Planning Act 2008 – Application by North Falls Offshore Wind Farm Limited for an Order Granting Development Consent for the North Falls Offshore Windfarm (EN010119)

I refer to the Rule 8 letter dated 4 February 2025 which sets out the Examination Timetable for the above Development Consent Order (DCO), currently at Examination. Essex County Council (ECC) in conjunction with Tendring District Council (TDC), and as described as The Councils, would like to provide a written response to the Applicant's submission at Deadline 4. Responses to ExQ2 are submitted separately.

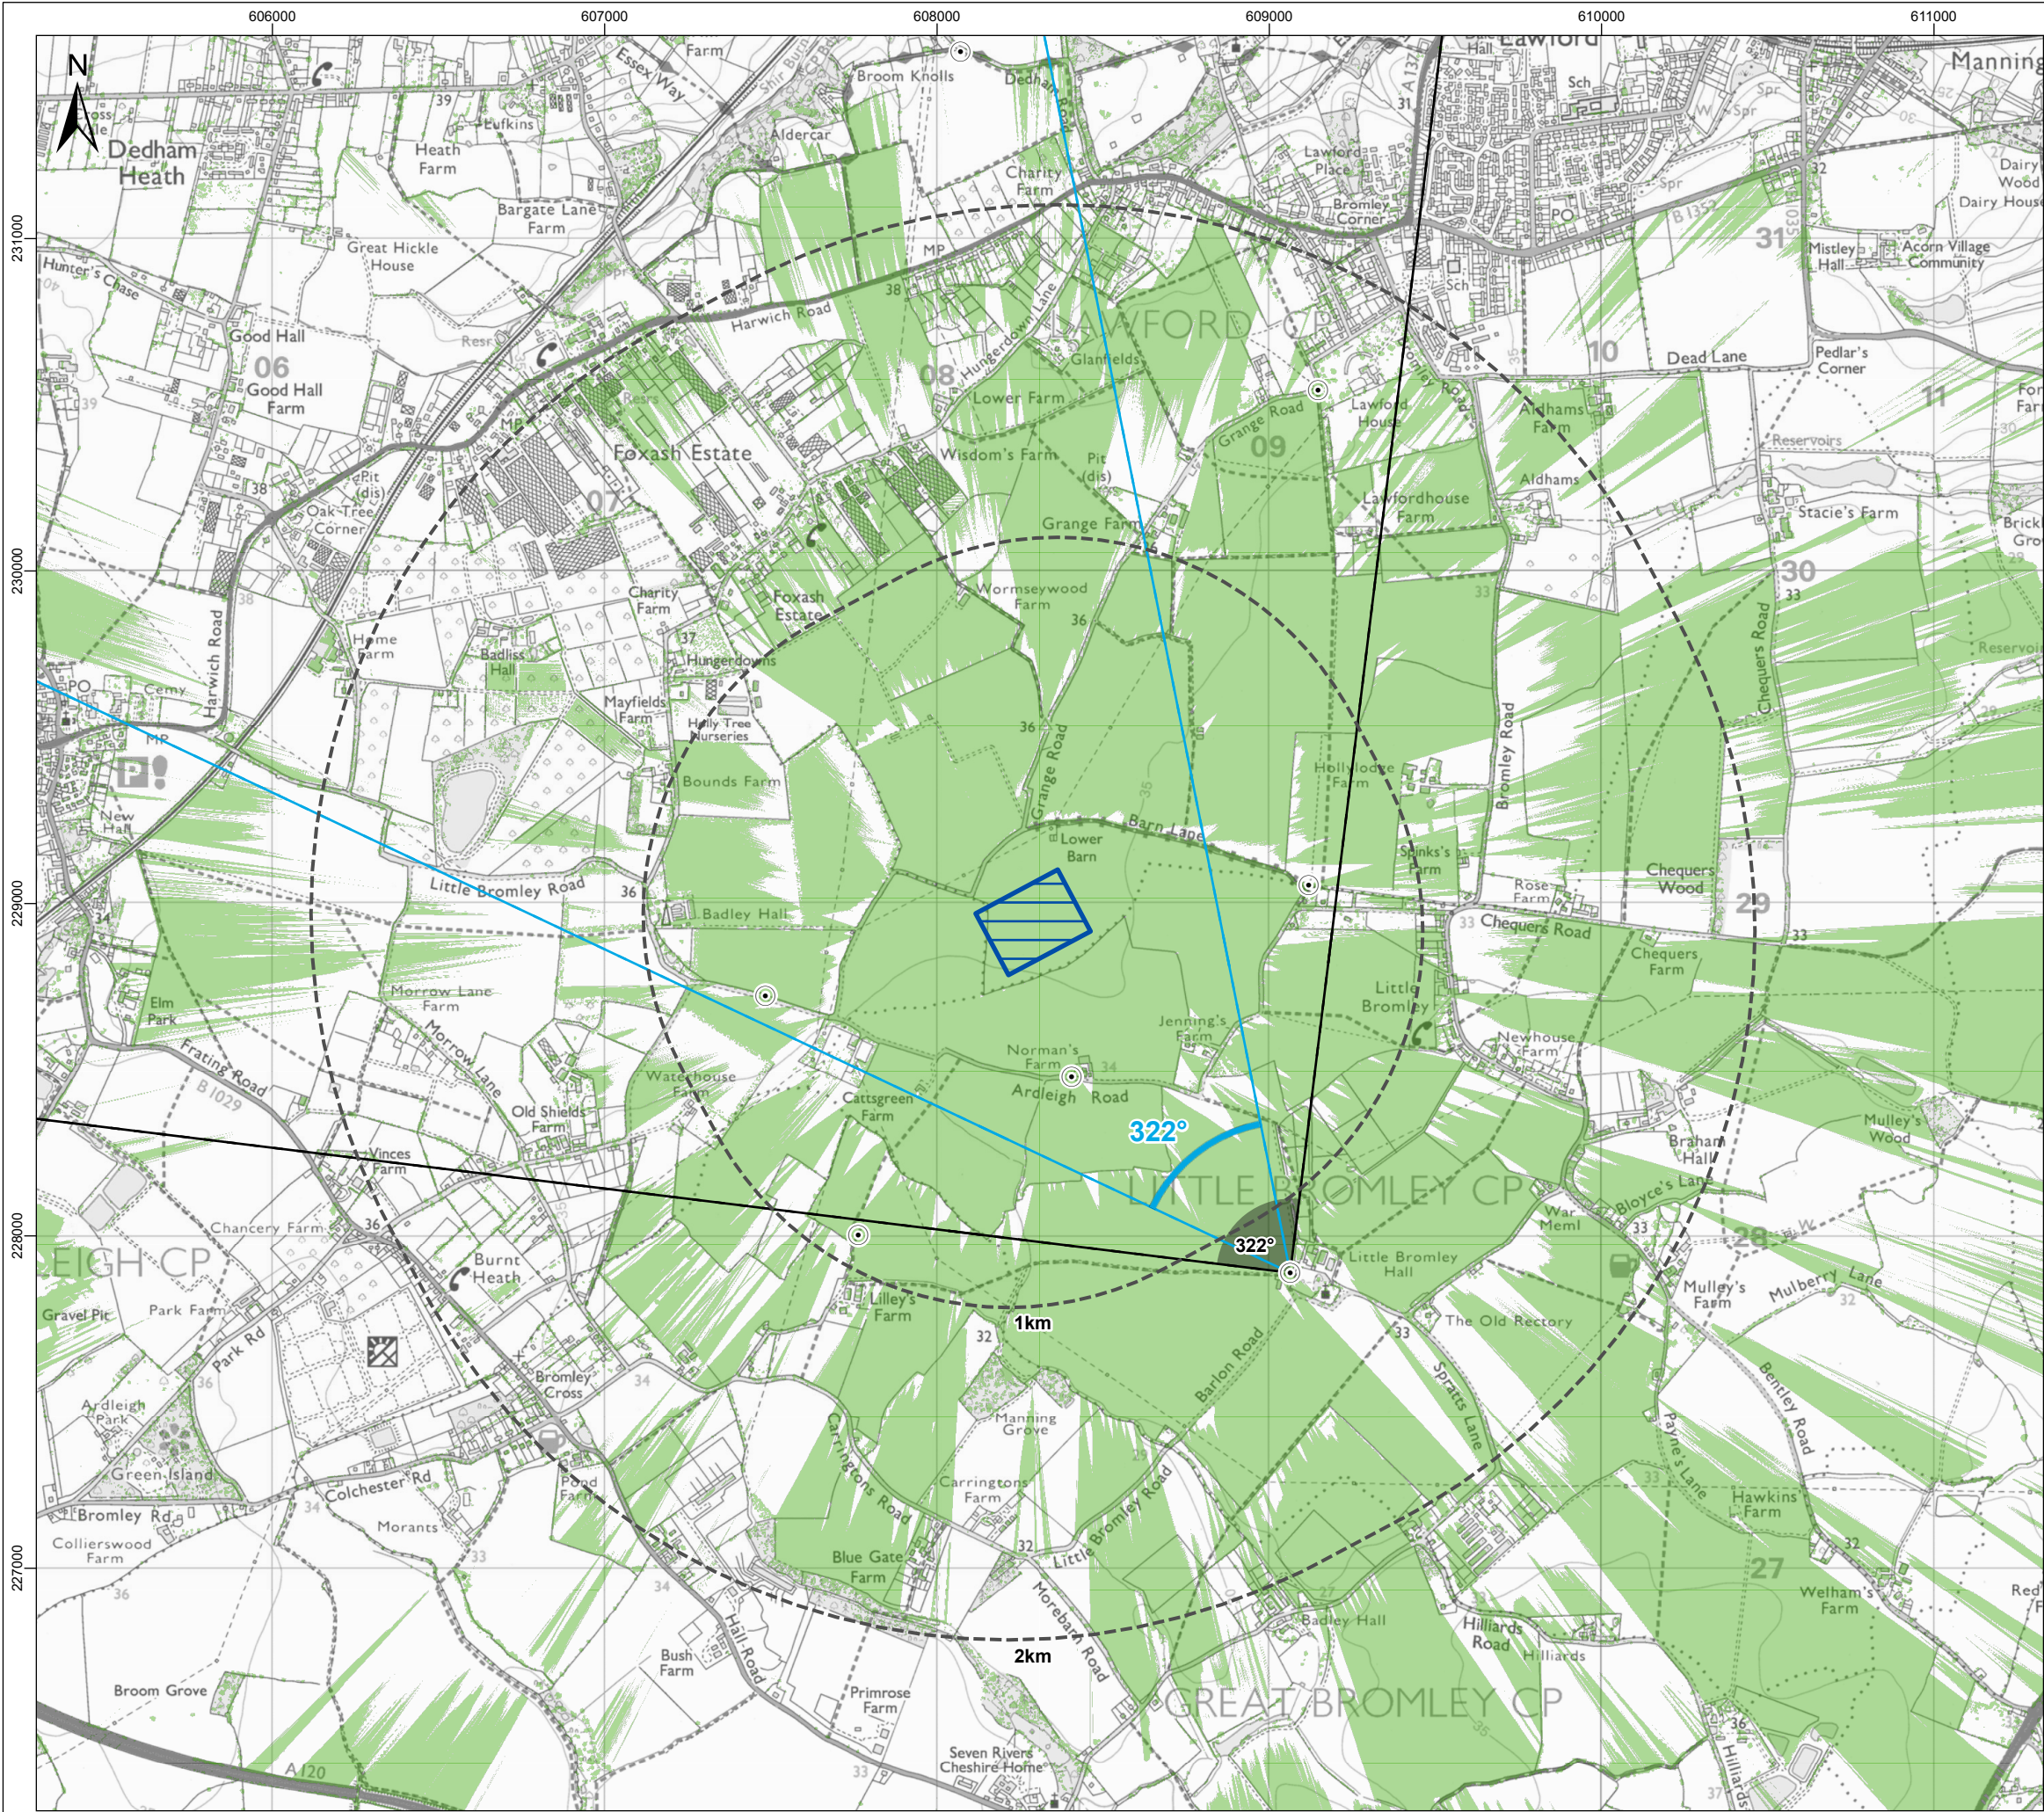
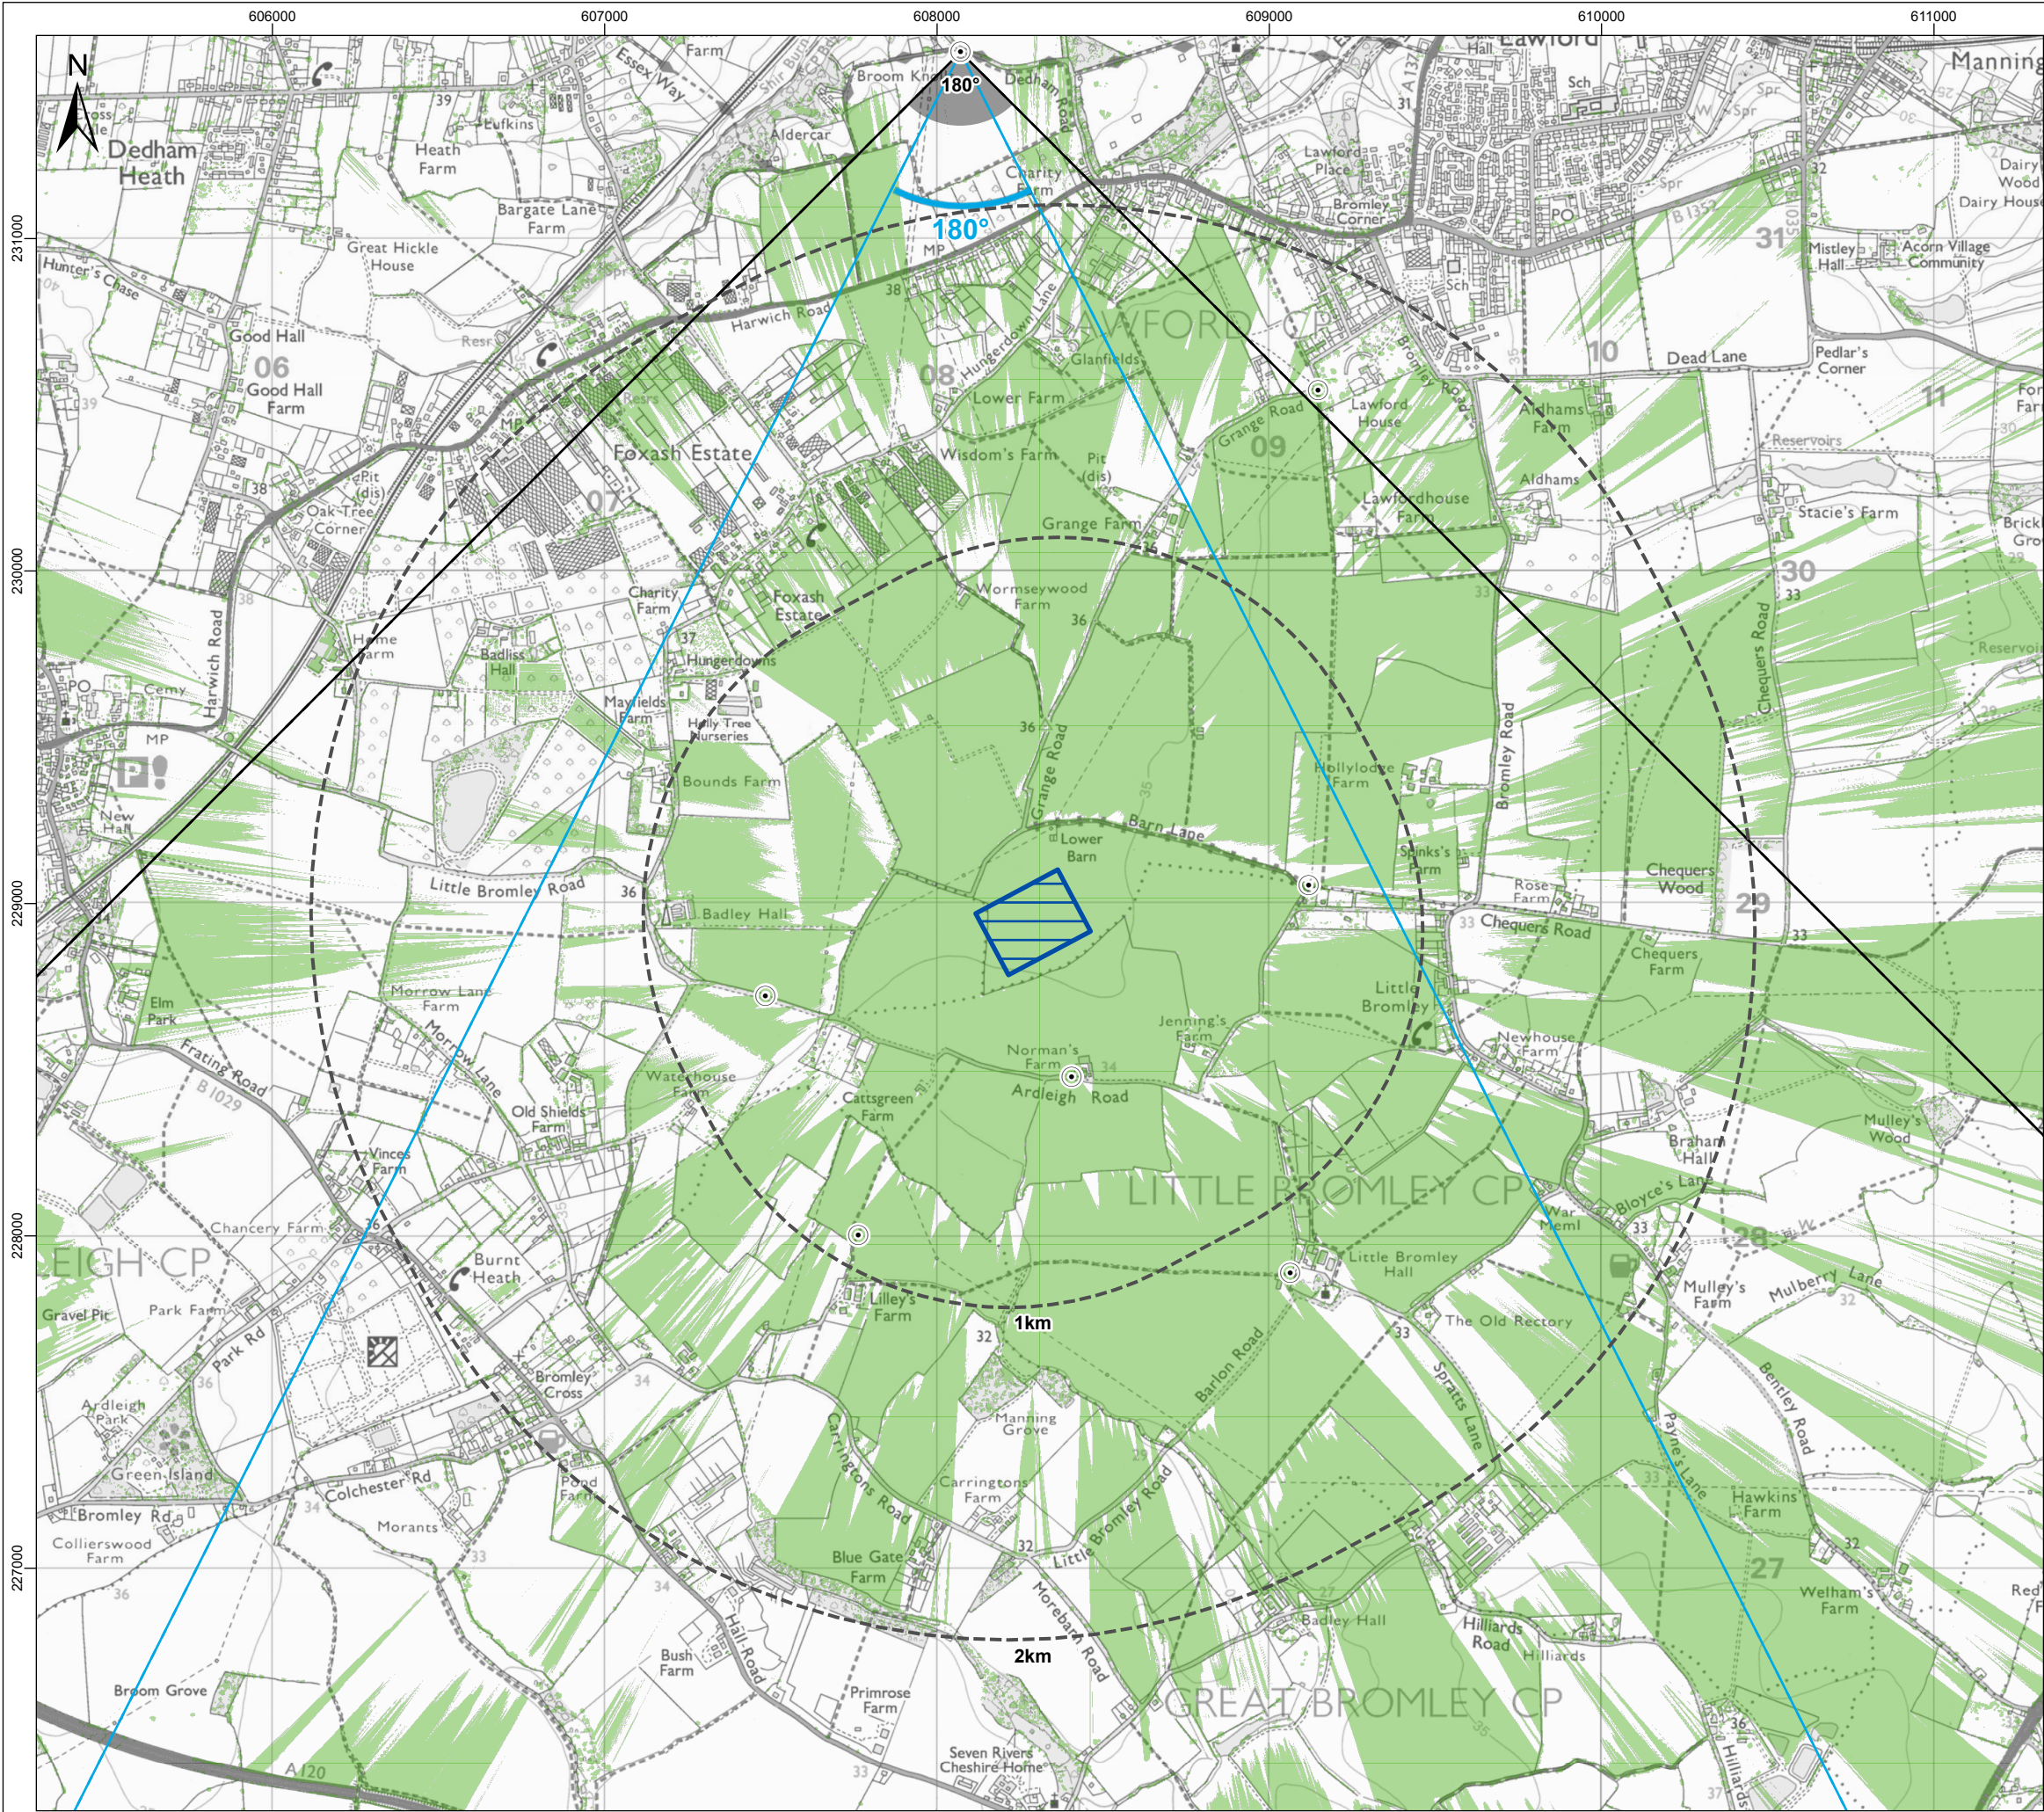
- VP 6 Grange Road c 1600m distance north
 - Demonstrates Year 1 would generate a likely Moderate negative i.e. significant impact
 - The N2T pylons are visible so add to the negative impacts but from this distance not significantly so.
 - However, for receptors closer to the installations along Grange Road these impacts will likely magnify. A viewpoint previously requested from Grange Road west of the installations rather than due north.
- VP7 Public Right of Way near Little Bromley Hall c 1,200m southeast.

- Demonstrates Year 1 would generate a likely Moderate/Major negative i.e. significant impact
- The N2T pylons are visible so add to the negative impacts but from this distance not significantly so.

- These impacts will likely magnify for receptors as they move closer to the installation's northwest along the PRow.
- VP 8 - Essex Way, Dedham Road c 2,400m north/northwest

- Demonstrates Year 1 would generate a likely Minor/negligible negative i.e. not significant impact due to the distance, intervening vegetation or topography and existing detractors.

- The N2T pylons are visible so create negative impacts but from this distance and with existing detractors not significantly so. However, the negative effect is likely more enhanced away from the existing pylons and potential for cumulative impacts on the setting to the National Landscape.
